11 August 2026

Re: State Significant Development Application No.SSD-82160220 (184 Fifth Avenue, Austral)

The Department of Education (the department) welcomes the opportunity to provide comments on the above State Significant Development Application (SSDA) and concurrent rezoning proposal (RP).

SHADOW DIAGRAM - 21 JUNE-9AM
SCALE: 1:1500@A1

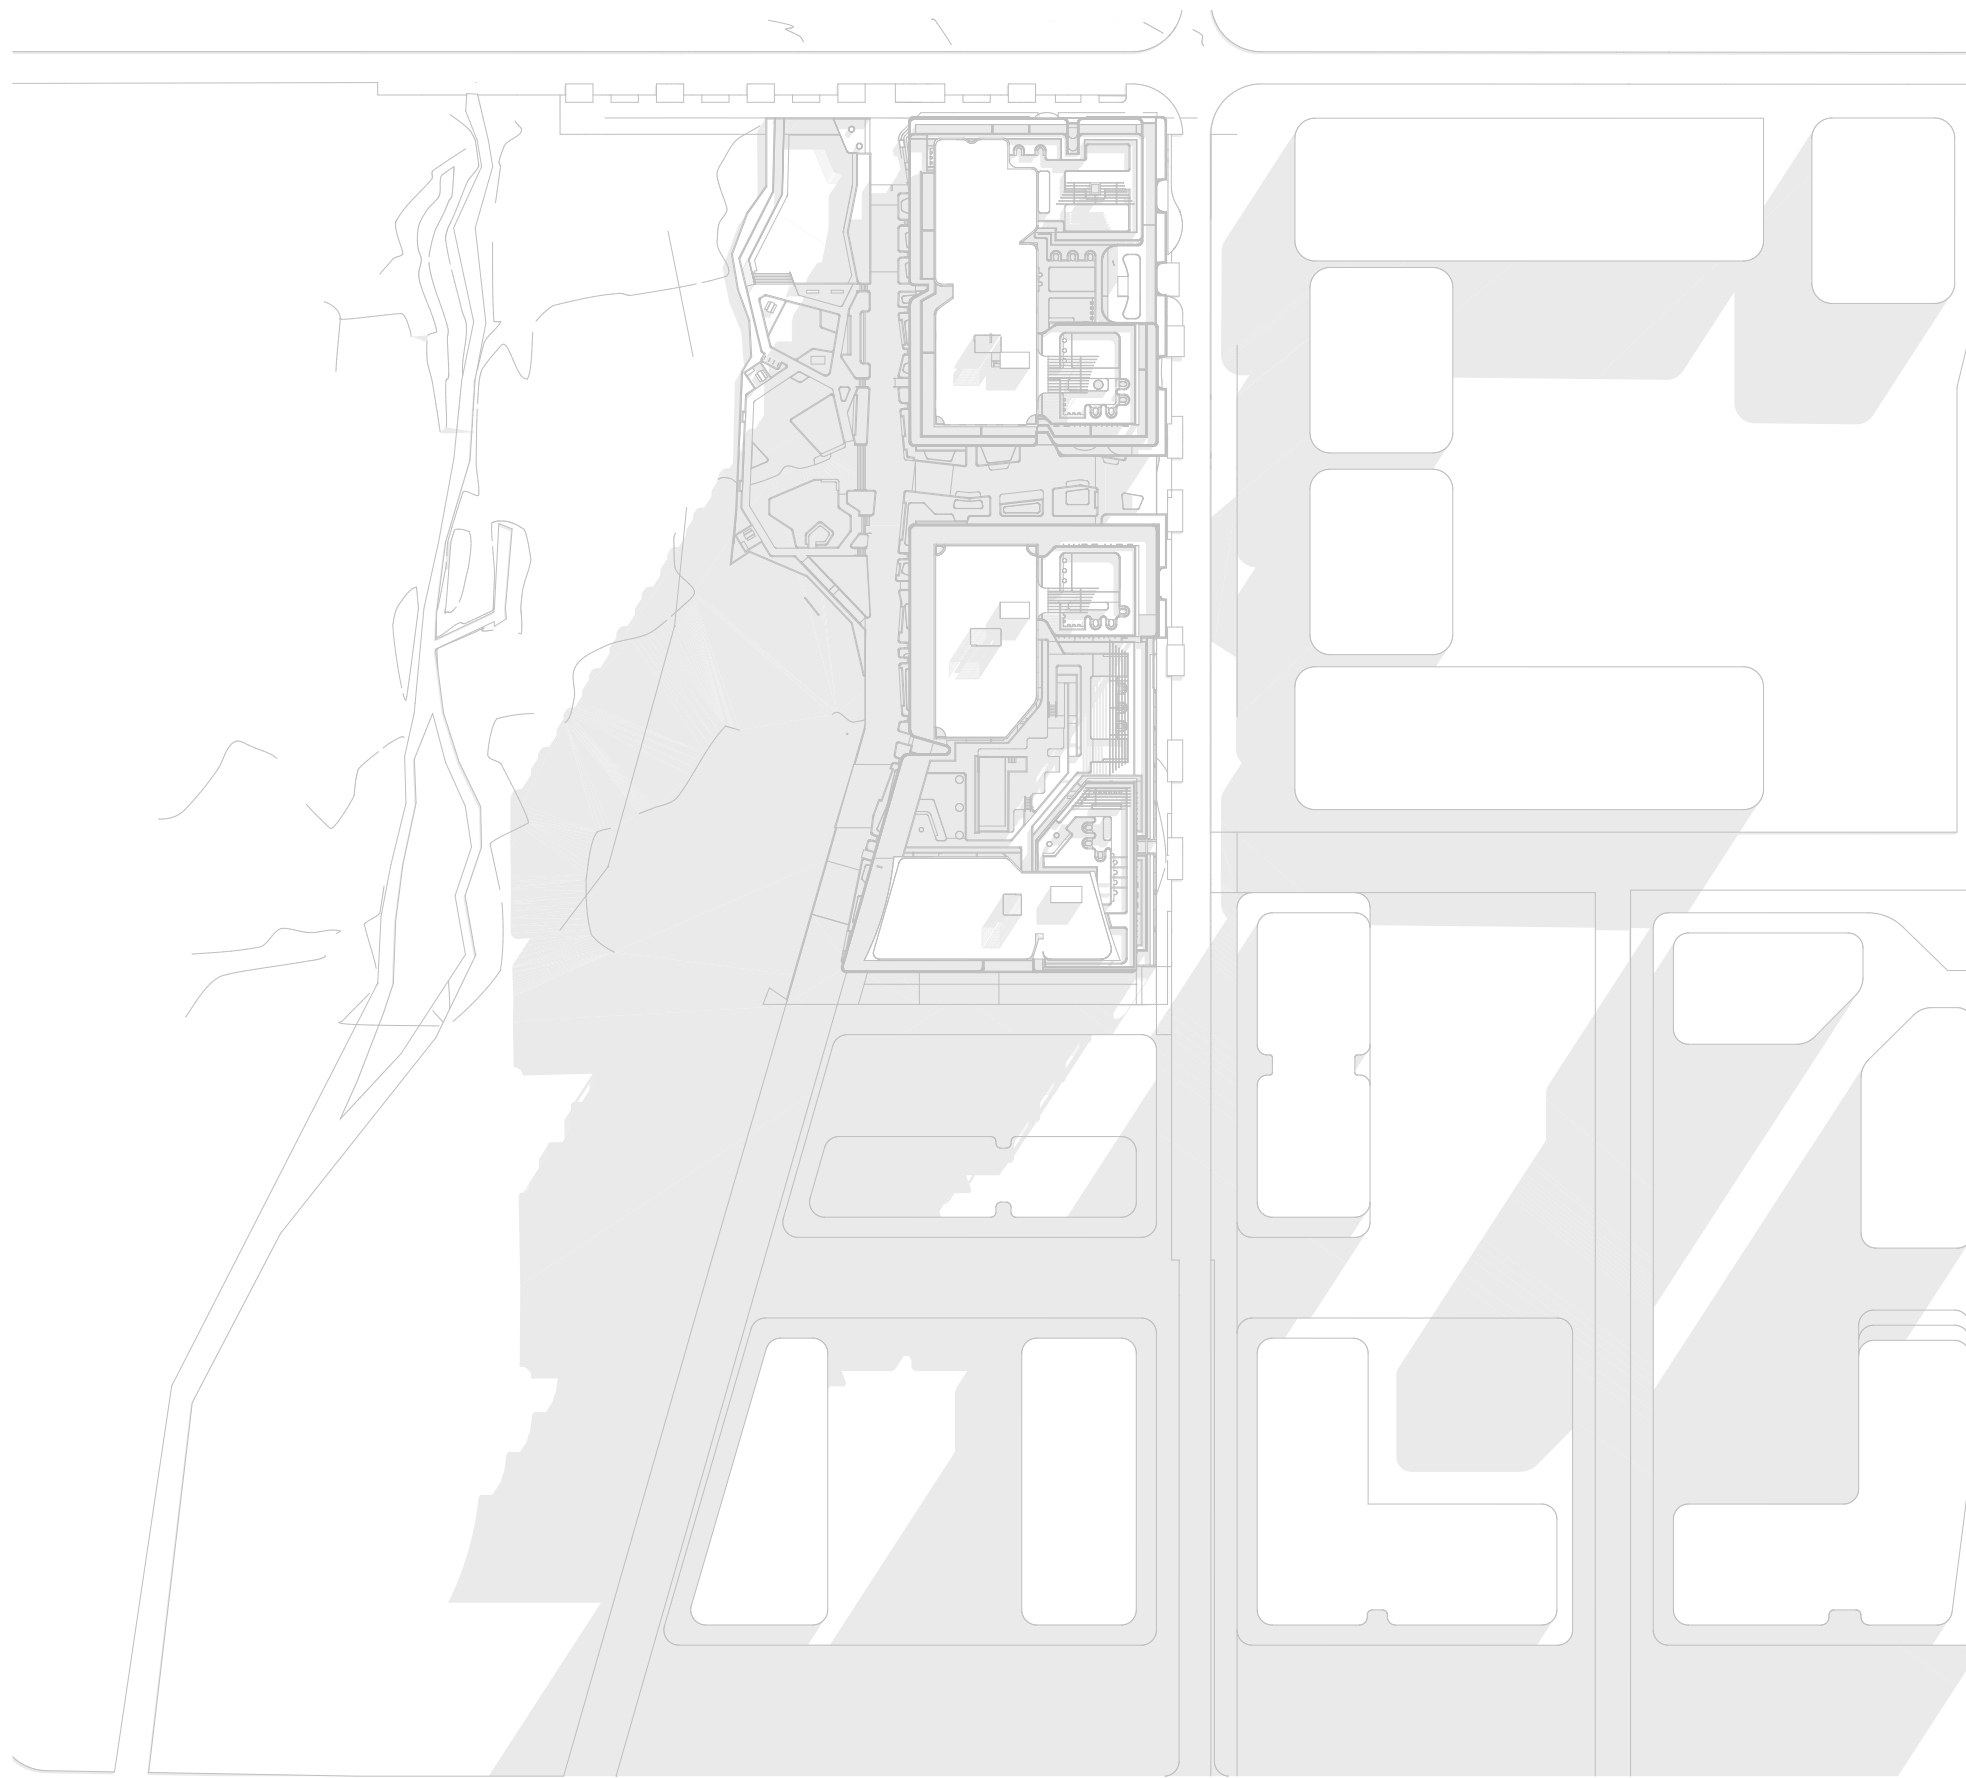
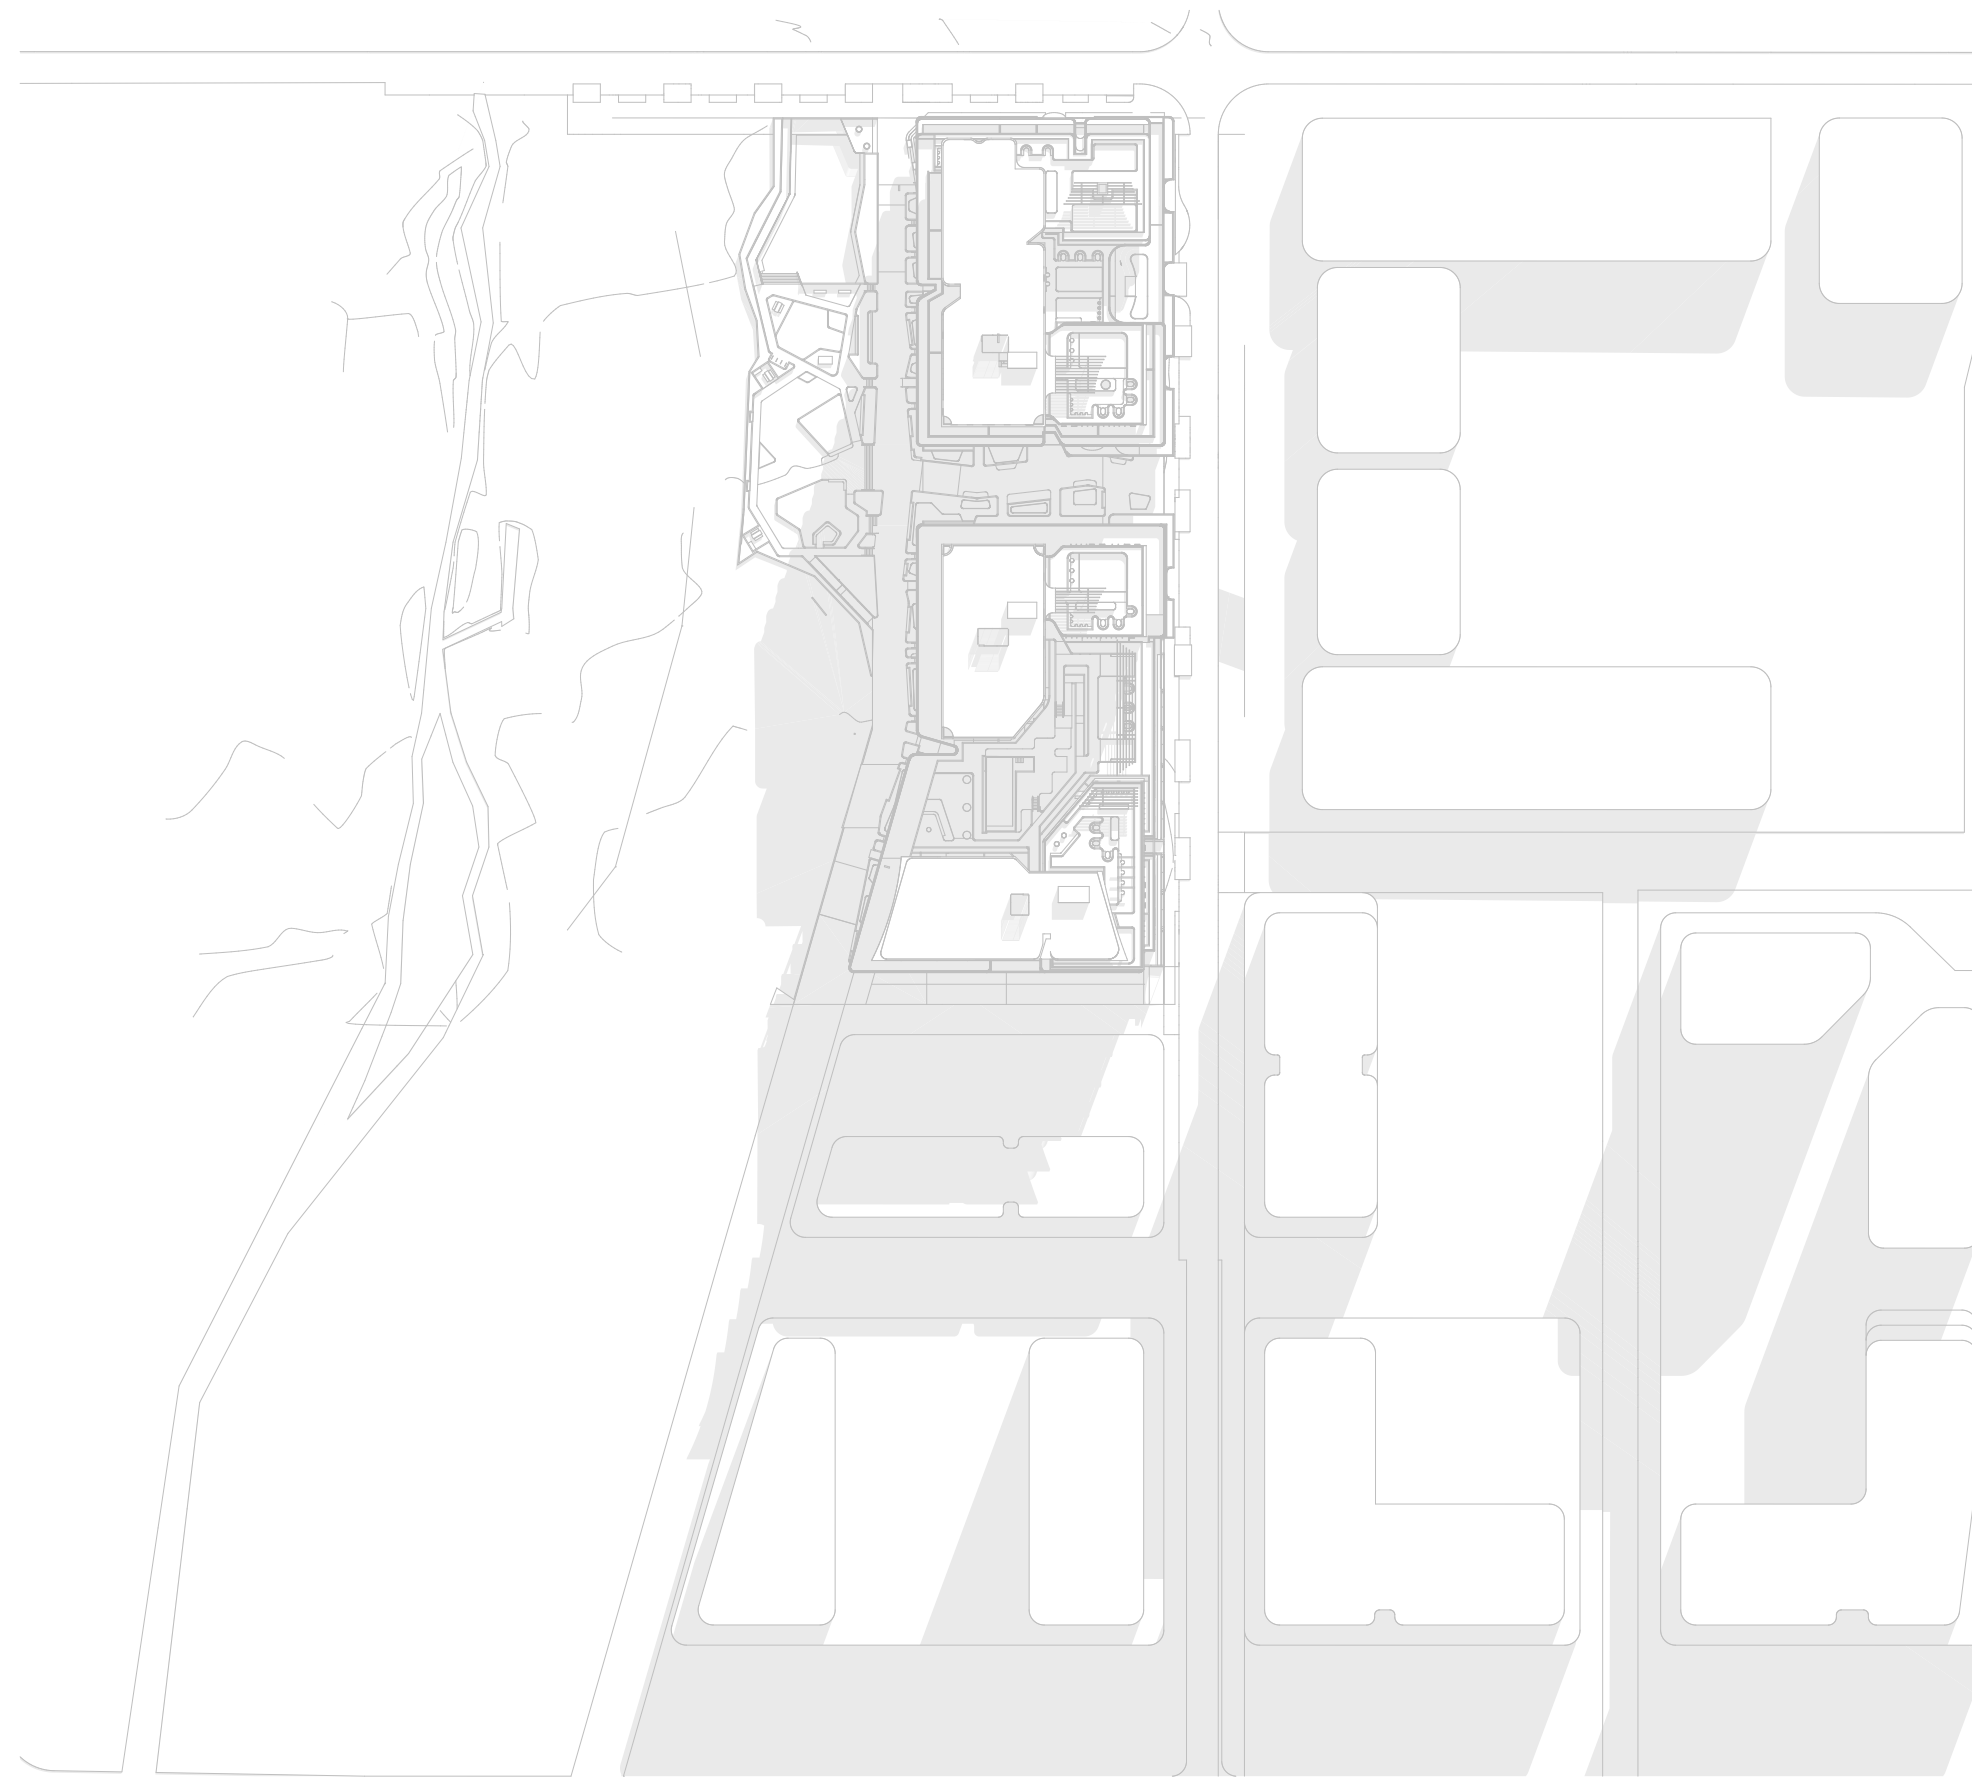
Overshadowing

The proposed development and rezoning propose significant up-lift in building height beyond that currently provided in Western Parkland City SEPP.

The siting and design of all proposed buildings should not have unreasonable overshadowing impacts on the proposed public school and public early learning facility. In particular, the development should ensure that the open play space areas and classroom buildings are not negatively impacted by overshadowing during school hours.
